WELWYN HATFIELD COUNCIL  
PLANNING CONTROL COMMITTEE – 5 JUNE 2008  
REPORT OF THE CHIEF PLANNING AND ENVIRONMENTAL HEALTH OFFICER

S6/2008/0035/FP & S6/2008/0045/LB

ERECTION OF REPLACEMENT RESIDENTIAL ANNEXE ATTACHED TO LISTED WALL, REPLACEMENT OF EXISTING FLAT ROOF GARAGE WITH PITCHED ROOF. AMENDMENTS TO S6/2005/1561/FP & S6/2005/1562/LB

THE VINES, HIGH ROAD, ESSENDON, HATFIELD, AL9 6HS

Job No: 528 Drawing No: 03D

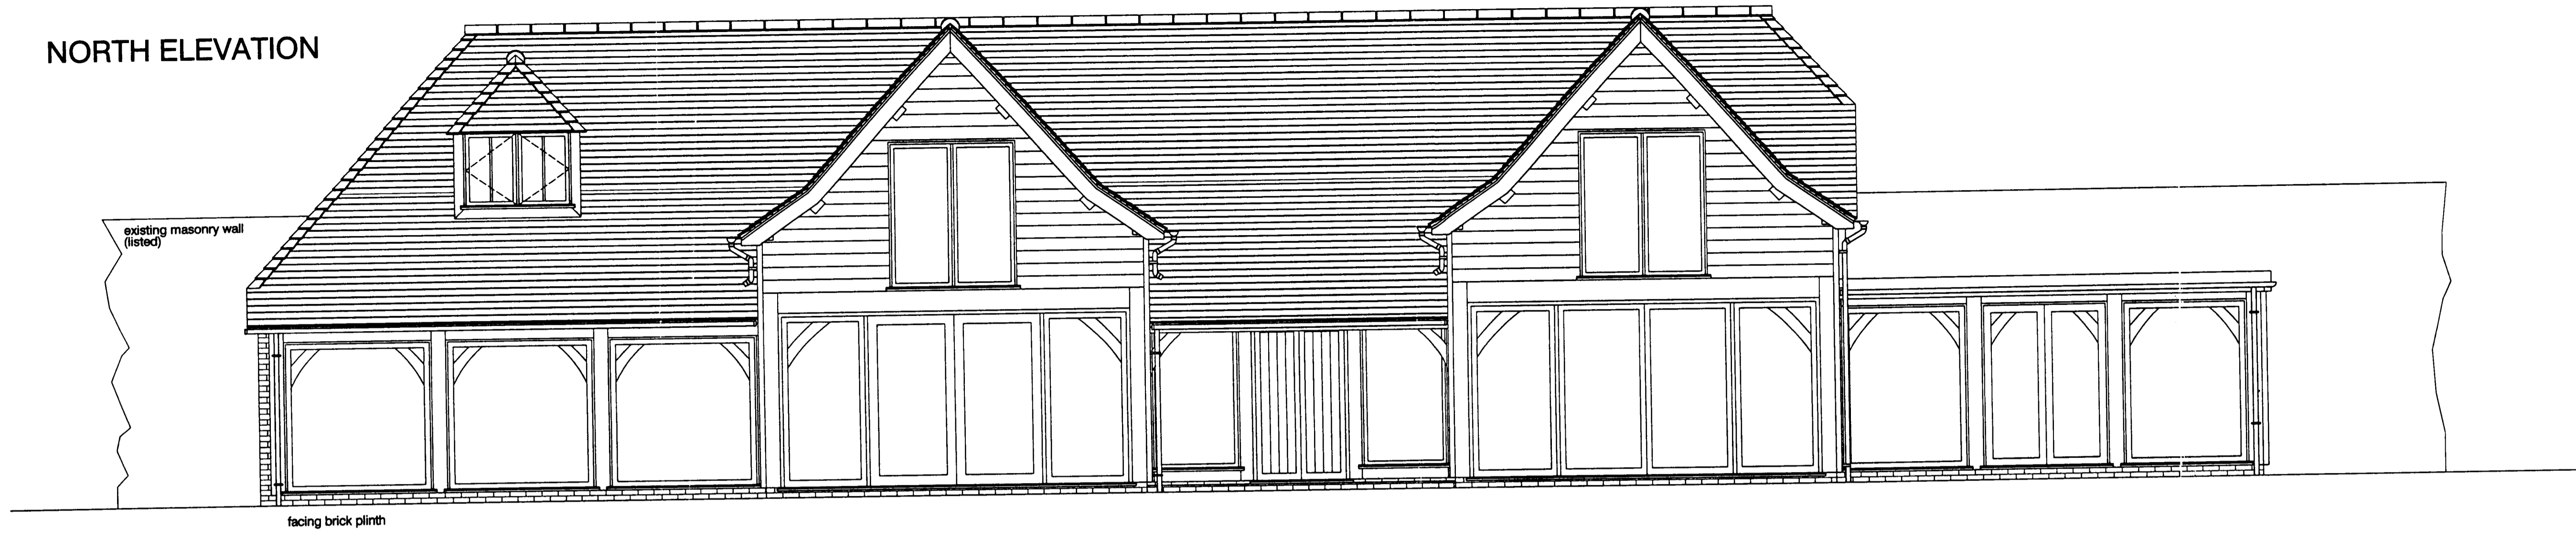
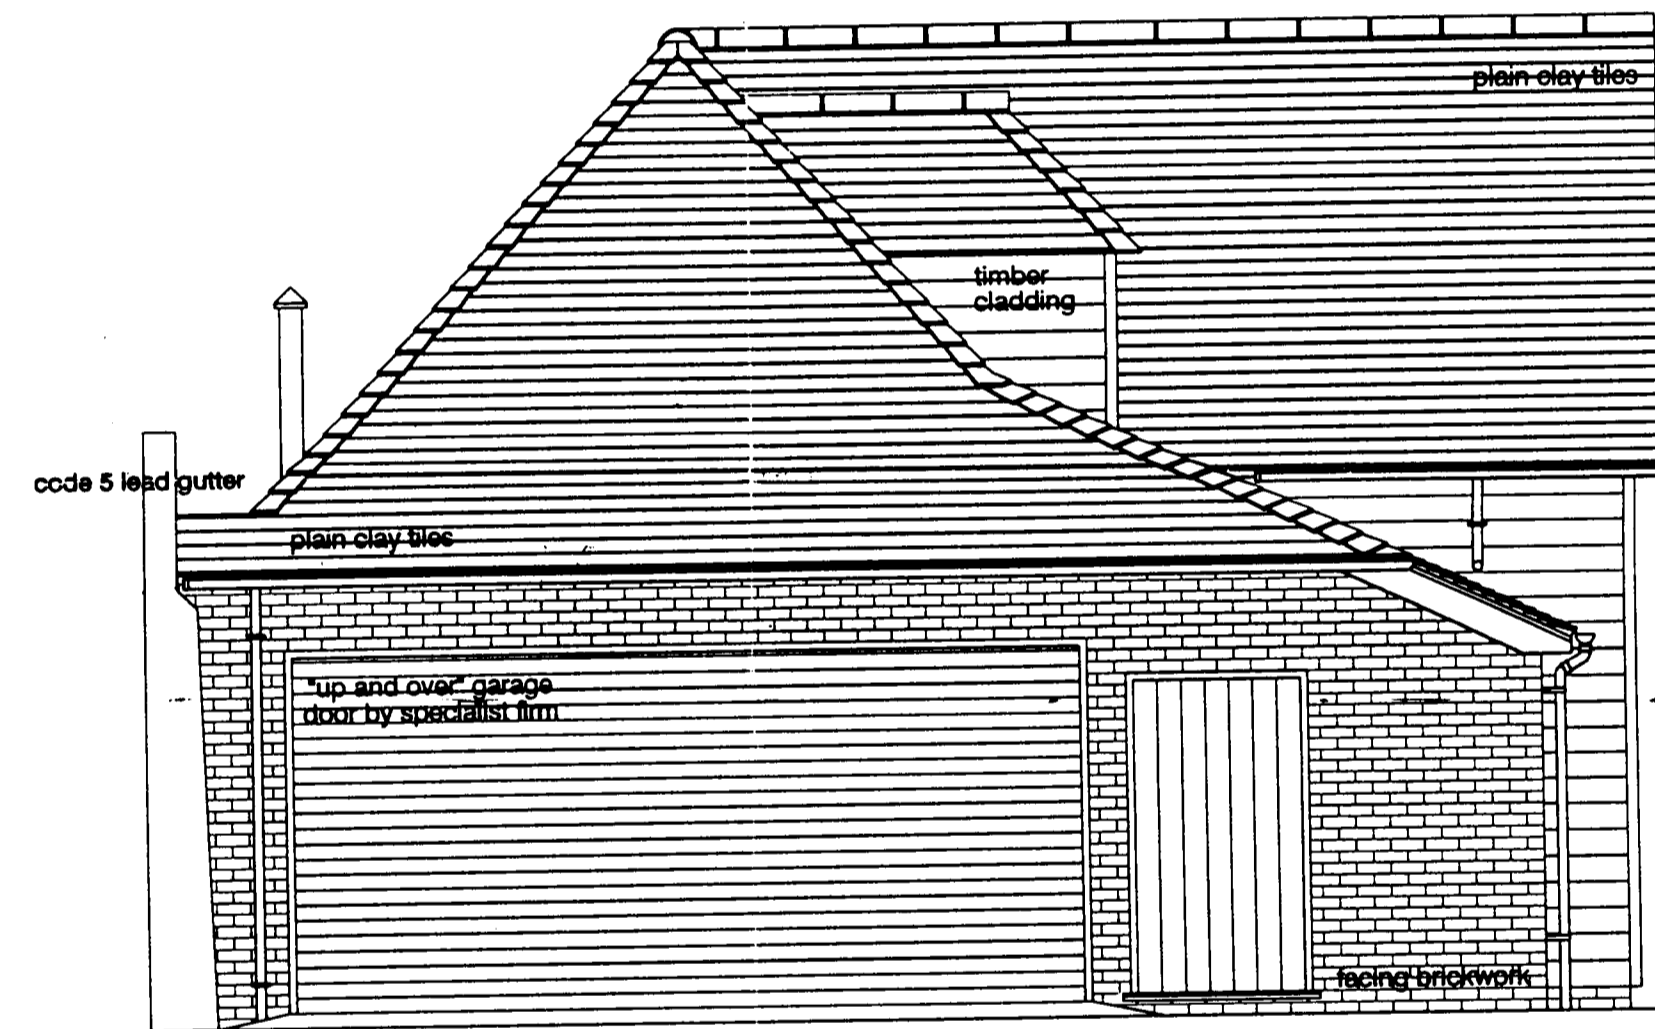
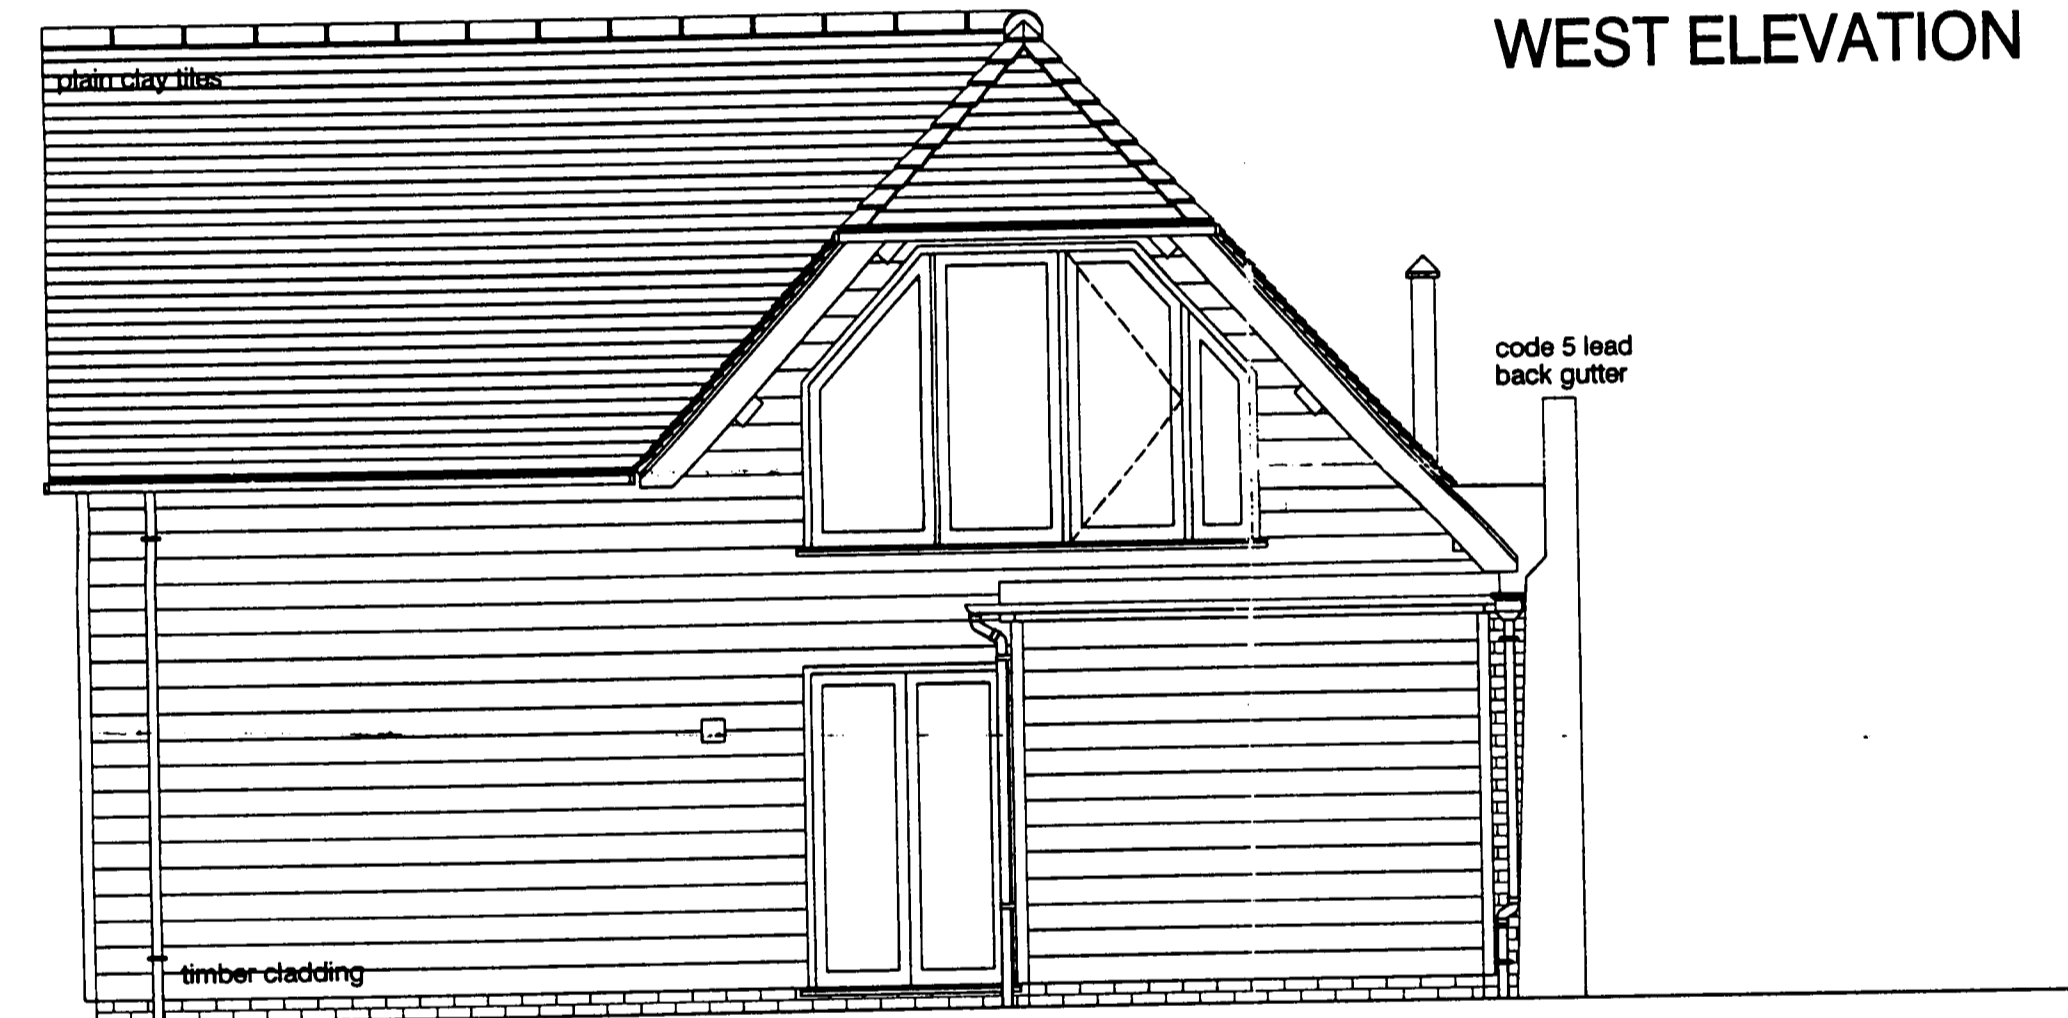
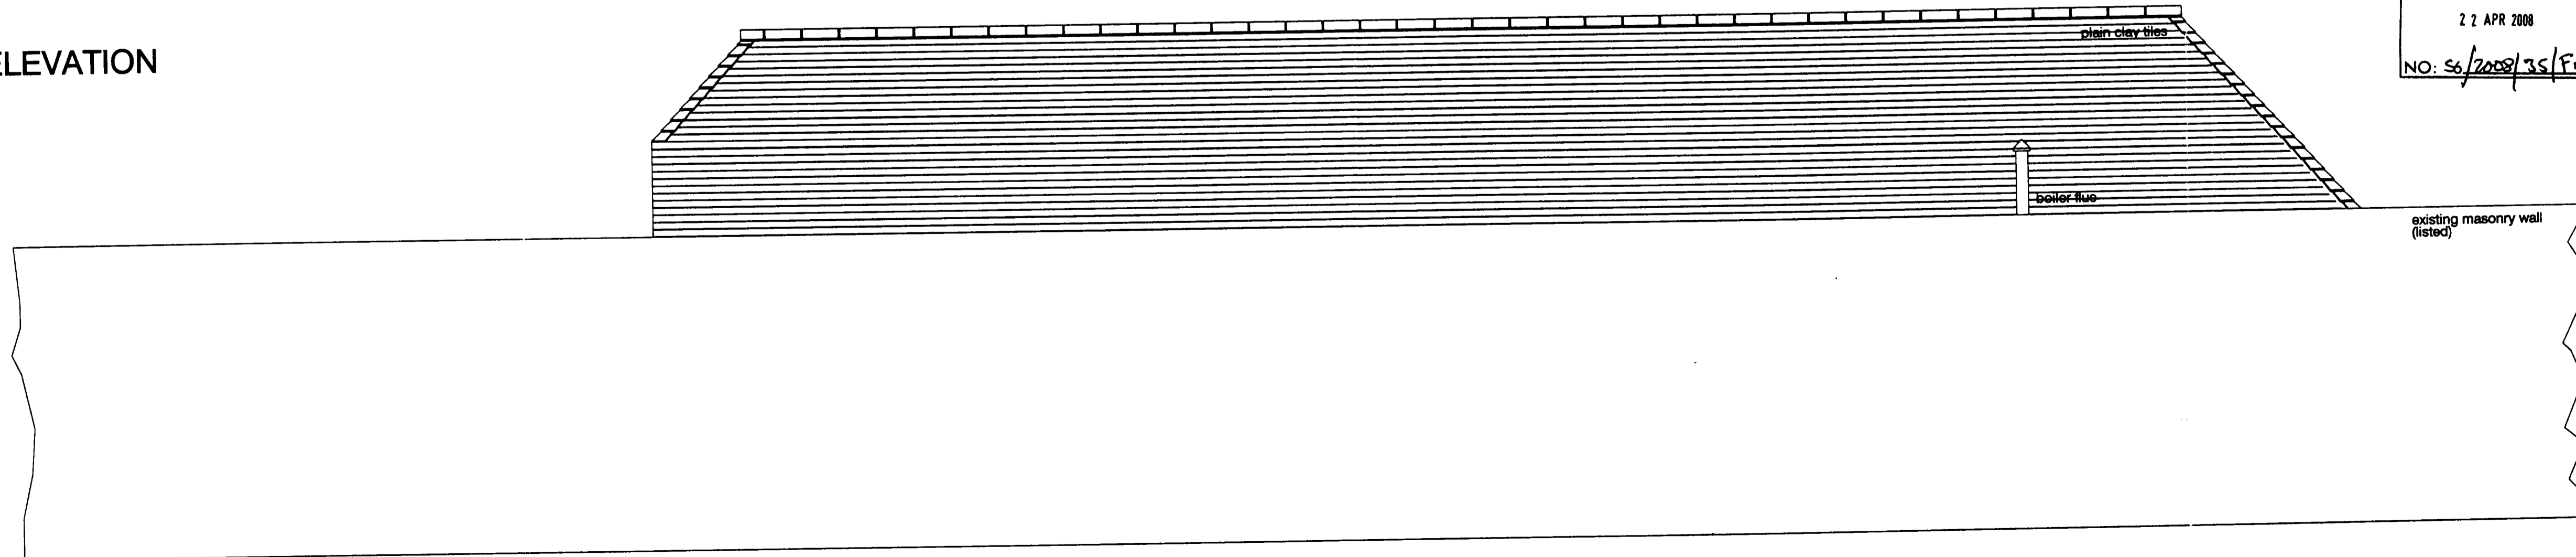
In design terms the main elevation is absurdly elongated and the clumsy extension to the roof, necessary to cover the extra width, is of notably poor design, particularly the eastern elevation now it has lost the earlier parapet device.

The dormer is much larger and is now clearly visible from the side and rear. The application should be refused due to size, bulk massing and design and the overlooking of the neighbouring garden.

the minor amendments to the dormer and the roof to the side extension.”

- The increased size of the dormer window over the garage which is extremely obvious from the adjoining dwelling, compared to the less obtrusive one previously approved

1. The alterations to the size of the dormers hereby approved, as shown on drawing number 528 03D, received and dated 22 April 2008, shall be completed within 6 months of the date of the decision
